Our Case Number: ABP-318802-24

Re: Proposed development of a resource recovery centre (including waste-to-energy facility)
in Ringaskiddy, County Cork.

OBSERVATION ON SID APPLICATION - Case reference: PA04.318802, Ringaskiddy Co Cork
Proposed development of a resource recovery centre (including waste-to-energy facility)
by Indaver NV t/a Indaver Ireland

Figure 8.4 Cork Airport Windrose 2021 -2025

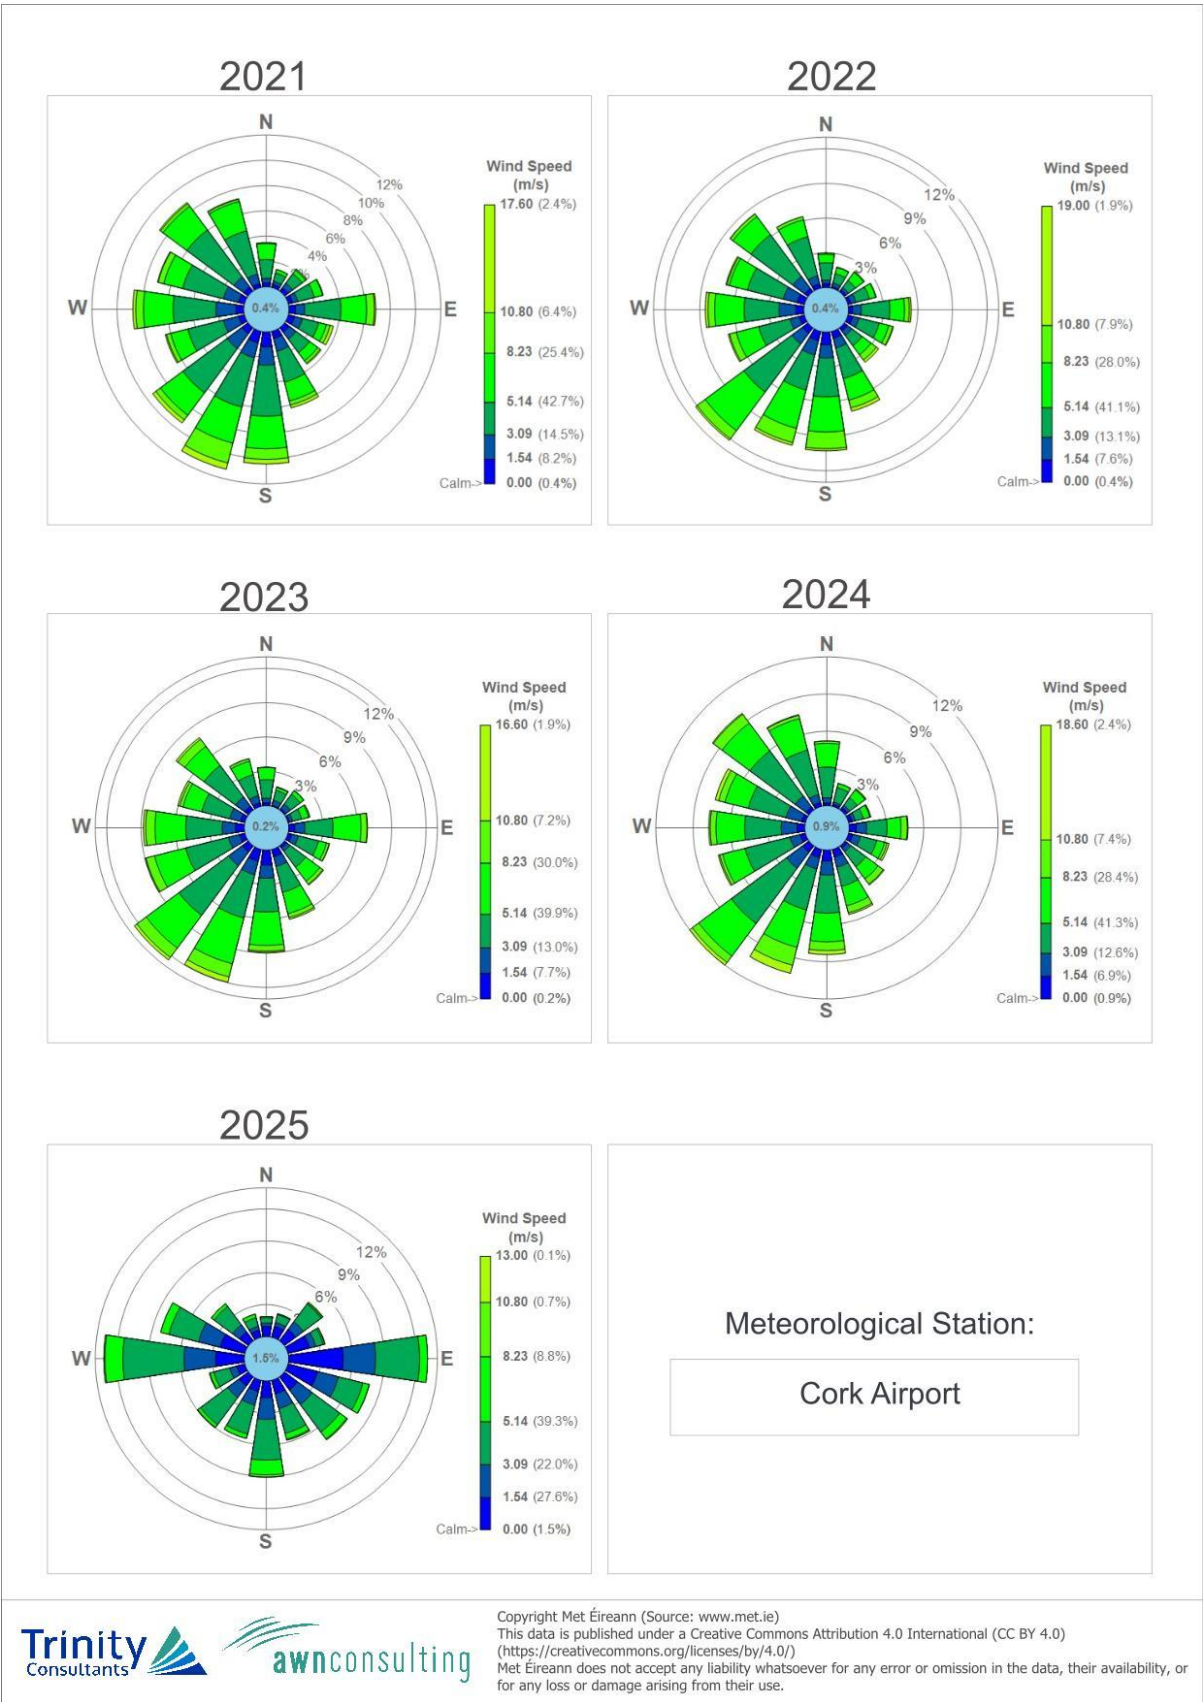
The section of the EIS pertaining to air quality modelling (8.2.2) retains the applicant's justification for basing modelling on Cork airport weather, an argument that rests on comparison between just over one year of local site records (October 2006 to December 2007) to airport meteorological records. The years 2020 to 2024 were used in the current appraisal, the previous application evaluated Cork weather from 1991 to 2020.

As part of the applicant's justification for reliance on Cork airport data, a sensitivity assessment of modelling input parameters was made. To validate assumptions about the accuracy of predictions made for the site area, meteorological data was drawn from Roches Point automated station (over an uncertain timeframe, probably 2018 to 2020, however these dates appear printed in Appendix 8.5 8.5.3 in reverse order). The report notes that Cork airport cloud cover was added to Roches Point data as this station did not report cloud cover. It should be noted that Roches Point lighthouse is at the mouth of the harbour, facing open water, arguably invalidating its use as a proxy for the applicant's site which is

I believe this strategy to be fundamentally unsound, brushing aside the obvious and significant effects that local topography has on cloud formation and meteorological phenomena driven by cloud cover.

The airport is located 500ft above sea level, a rise in elevation that occurs in approximately 2.5km. Under critical atmospheric conditions (wind direction, air pressure and moisture content) wind flow over this rising terrain will create or thicken cloud over the airport compared to adjacent areas. Regardless of orographic lifting, meteorological wind gradient theory would lead one to expect wind strength to be greater than at sea level, and wind direction to also differ.

The EIS acknowledges 'some differences in surface characteristics are apparent between the meteorological station at Cork Airport and the proposed development site location' without elaboration, rather turning to the results of their own sensitivity study which uses averaged values based on a short period of on-site observation that minimises impacts of short-lived phenomena that may not occur consistently every year, to dismiss differences.

Given the obvious topographic differences between Cork airport and the lower harbour area, accepting modelling data based on a single year of comparison to site conditions not only skews overall confidence in modelling results but also ignores micro-climate effects that could potentially lead to short-term episodes of higher-than-average air pollution in urban areas fringing Cork harbour. These areas may be subject to local low-level local wind circulation that flawed modelling would not reveal or underestimate.
